July 2, 2014

RE: Site Plan Revisions  
Lot 15-Skylark Commons Subdivision  
Project ID 2014-1056

**Comments from Philip DiPierro, Development Review Coordinator, dated June 26, 2014:**

SITE PLAN-LOT 15

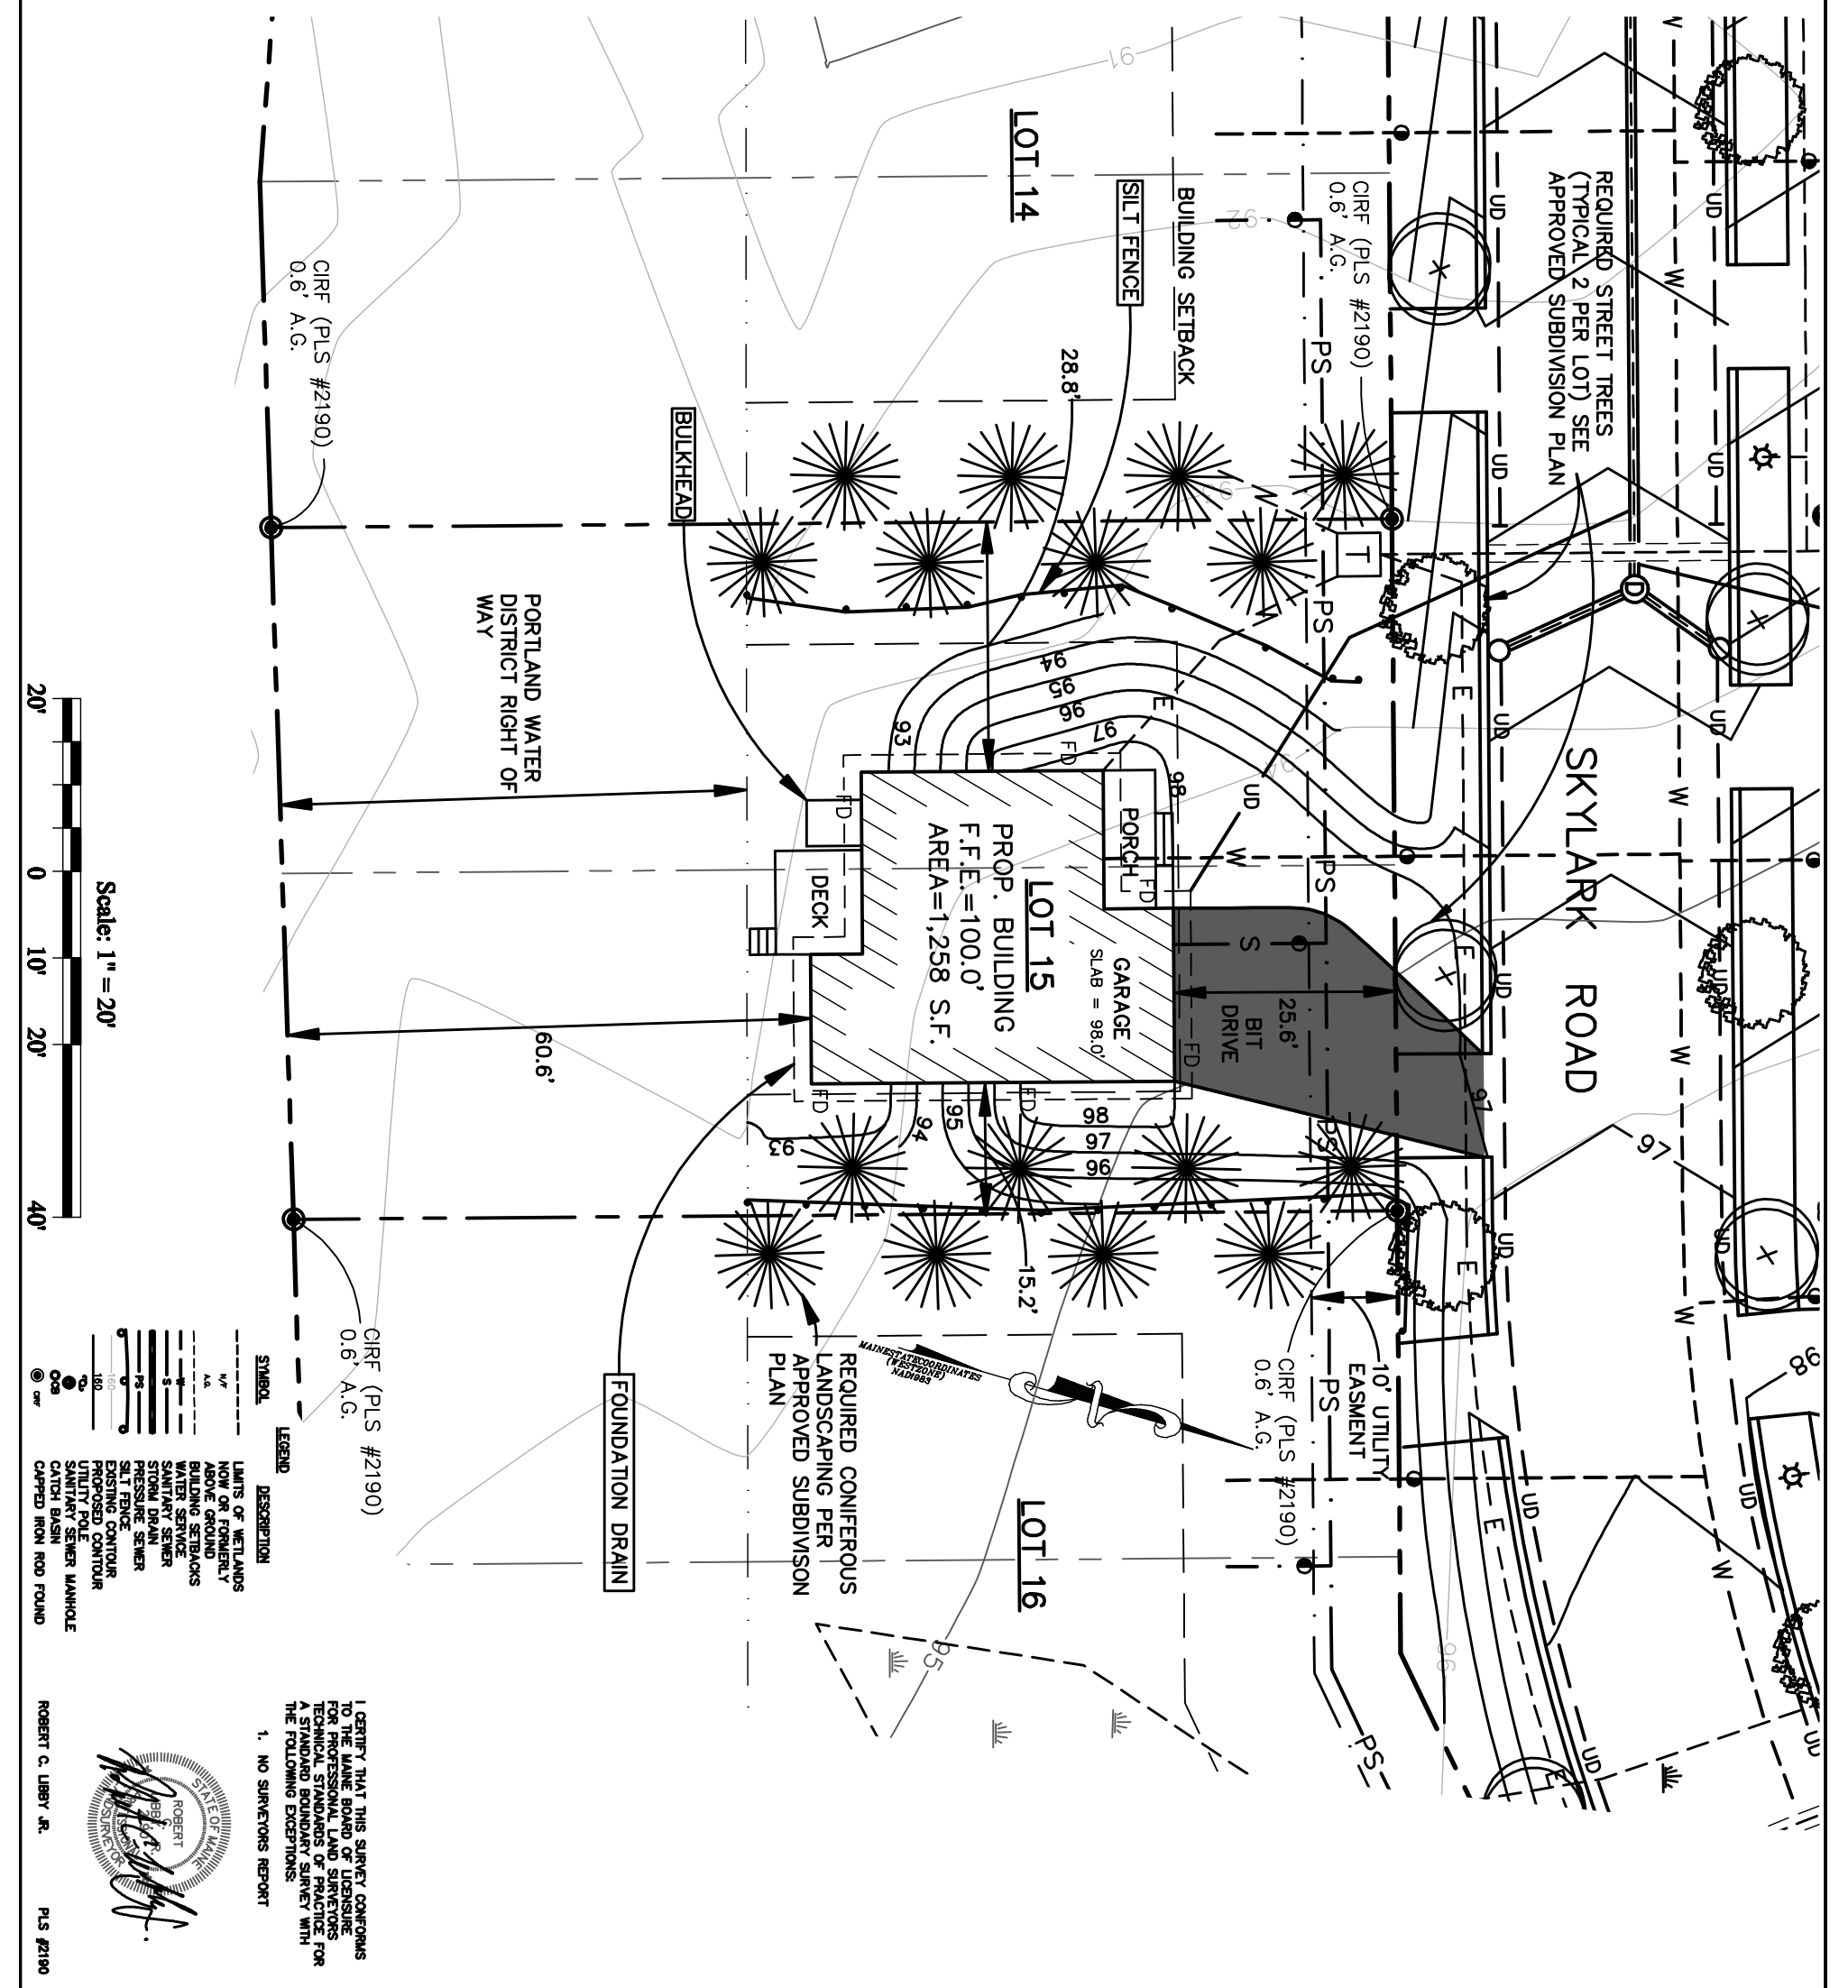
1. As you know we talked on the phone this afternoon about this site and I feel we are both on the same page regarding the revisions that need to be made on the development of Lot 15. We have adjusted the grading to address your concerns on the impacts to abutting lots as well as general compliance with the approved grading plans. The building on Lot 15 is no longer proposed as a walk out basement. The grading now reflects the original approved subdivision plans as well as the submitted building elevations. Please note that a small ditch was also added along the Western limit of development to assure that runoff from the Western side of the proposed building does no adversely impact the abutting developed Lot 14. This ditch will direct runoff Southerly. Please also note that a stone checkdam has been added at the end of this ditch for erosion and sediment control purposes. We have also extended the grading from the Easterly side of the proposed house on Lot 15 onto Lot 16 as we discussed

to assure that a low spot is not created between these two lots that could prove to be problematic in the future. The development of Lot 16, when it occurs, can now tie into these contours and create the general drainage conditions approved on the original subdivision plans. This revision also will help the proposed plantings along the Easterly side of the proposed lot as they will now be installed on more level ground. Please also note that the foundation drain around the house remains connecting to the stormdrain system within Skylark Road. These revisions bring the development of Lot 15 into compliance with the approved grading plans as part of the original subdivision approval and will assure that no adverse impacts result from the development of this lots on the abutting lots or downstream conditions.
